Consultation Response from: KC Environmental Health (Pollution & Noise Control)
2023/90411 The Co Operative Food, 2-4 Station Road, Shepley, Huddersfield, HD8 8AA
Advertisement Consent for installation of illuminated and non-illuminated signs (within a Conservation Area)
Responding Date:
8th March 2023

Responding Ref:
WK202305960

External _V6_Planning

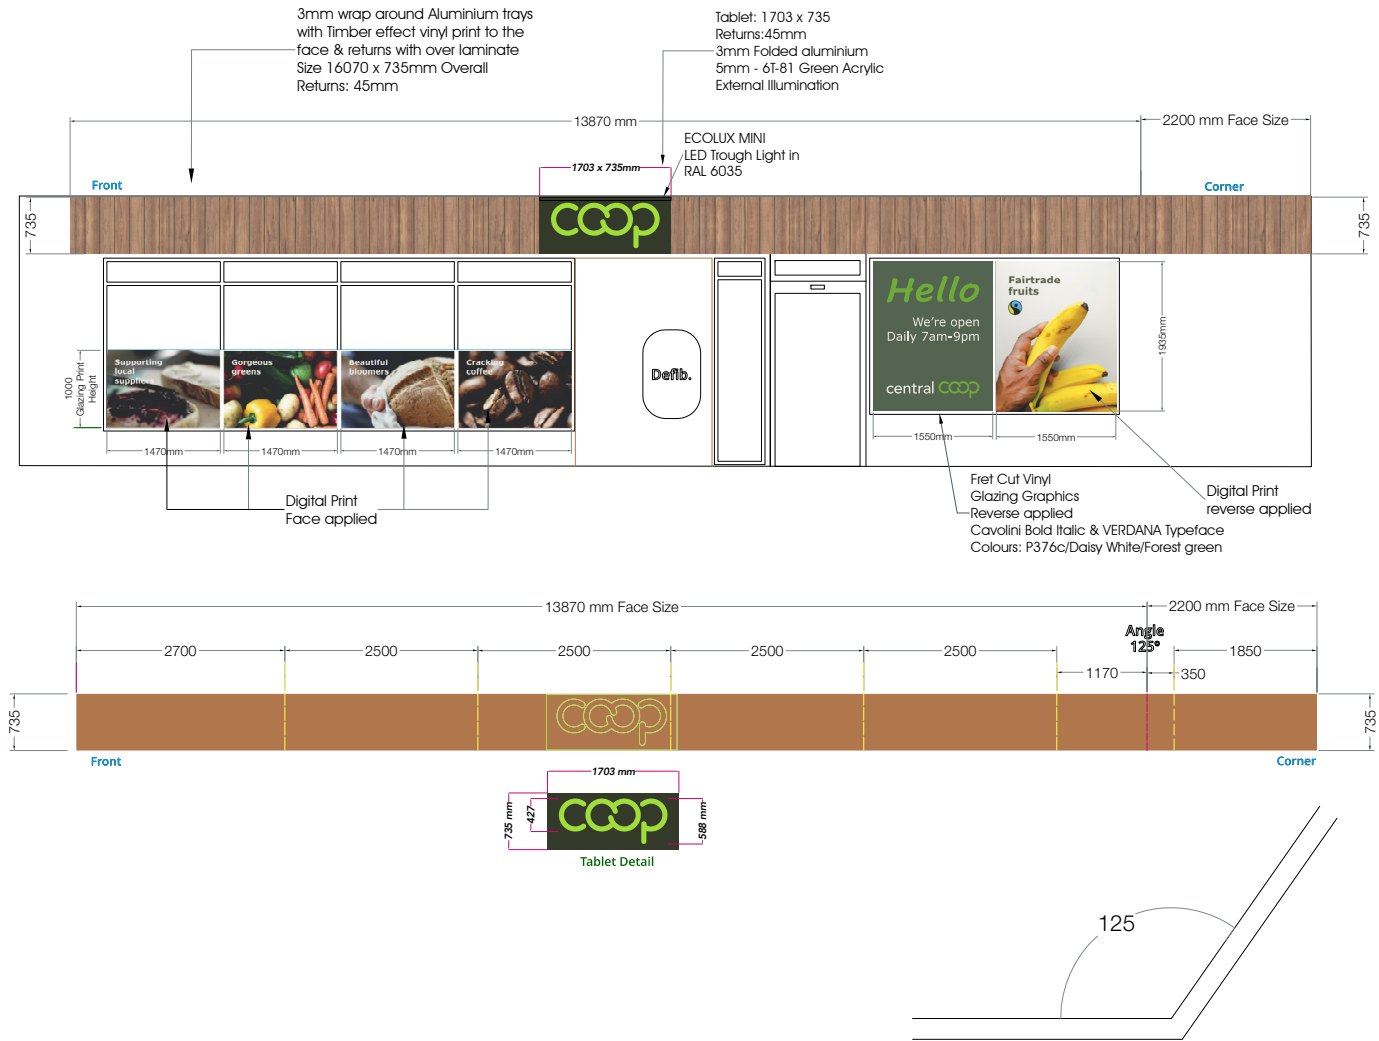
We have reviewed application 2023/90411, our comments are in relation to the levels of illumination for a single static illuminated sign only.

The application clarifies the surface area of the sign to be greater than 10m², with a maximum illuminance level of 200 cd/m².

We consider the environmental zone in the area to be 'Rural' (Zone 2), 200cd/m² is the maximum level recommended in The Institute of Lighting Professionals PLG05 document, Table 4 (maximum permitted recommended luminance).

The village location will have lower levels of light pollution, we have concerns that the illuminated signage could disturb the amenity of the residents who are directly opposite. We therefore recommend a condition to limit the illumination of the signage to mimic the store opening times.

The illuminated advertisement hereby permitted shall:

- be installed and maintained thereafter in accordance with the approved plans
- shall not be operated between the hours of 21:00 and 07:00 on any day of the week
- have a luminance not exceeding 200 cd/m² at any part of the illuminated area.
